SHOALHAVEN CITY COUNCIL

ENVIRONMENTAL ASSESSMENT REPORT SUBMISSION MAJOR PROJECT APPLICATION - CONCEPT PLAN MP09_0088

DEPARTMENT OF PLANNING REFERENCE: MP09_0088

COUNCIL REFERENCE: 3A10/1003

Fig 3. The Circus design rules

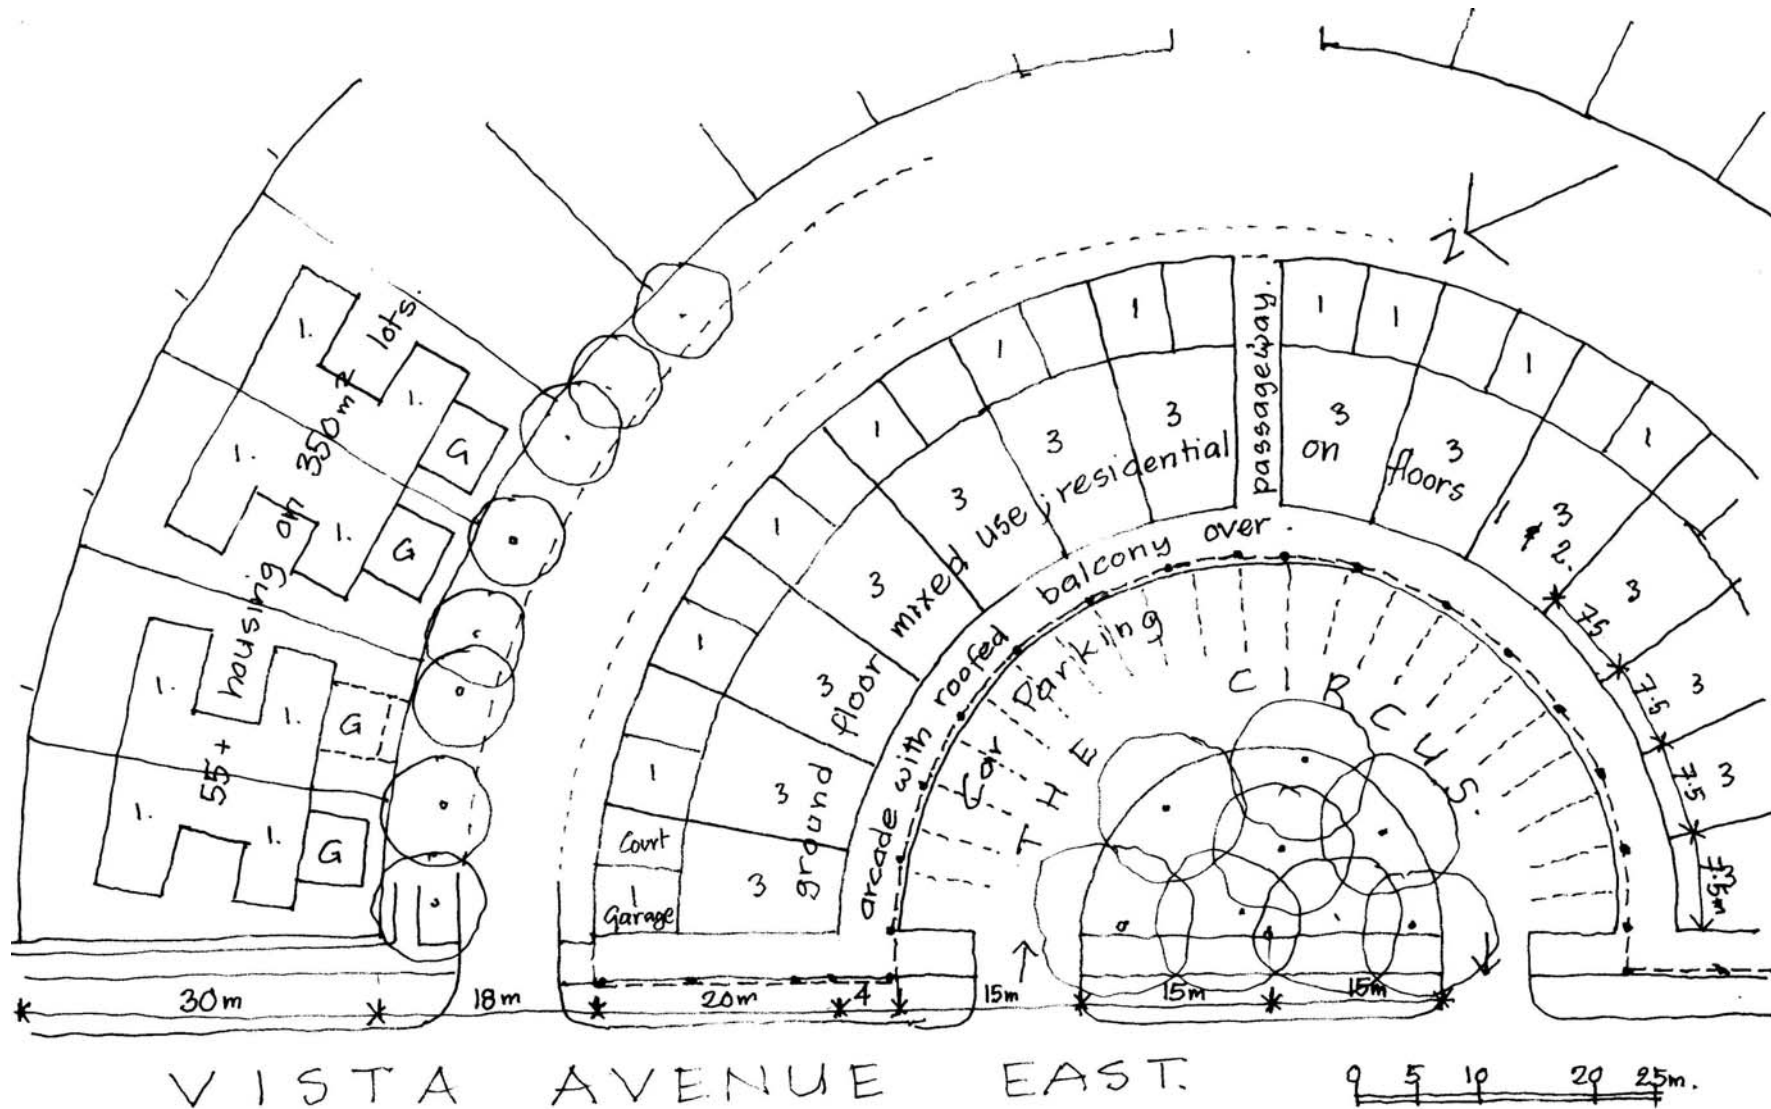
- (a) The apparent lack of delivery vehicle parking for the mixed use / residential uses.
- (b) The potential congestion for car parking described in Appendix V - Figure 3 when combined with a through road system at the centre and two small landscaped parks that are disconnected from the commercial mixed use lots. Further detail is requested for The Circus to confirm sufficient parking is available for the proposed commercial development, including for delivery vehicles, and the extent of public road dedication.
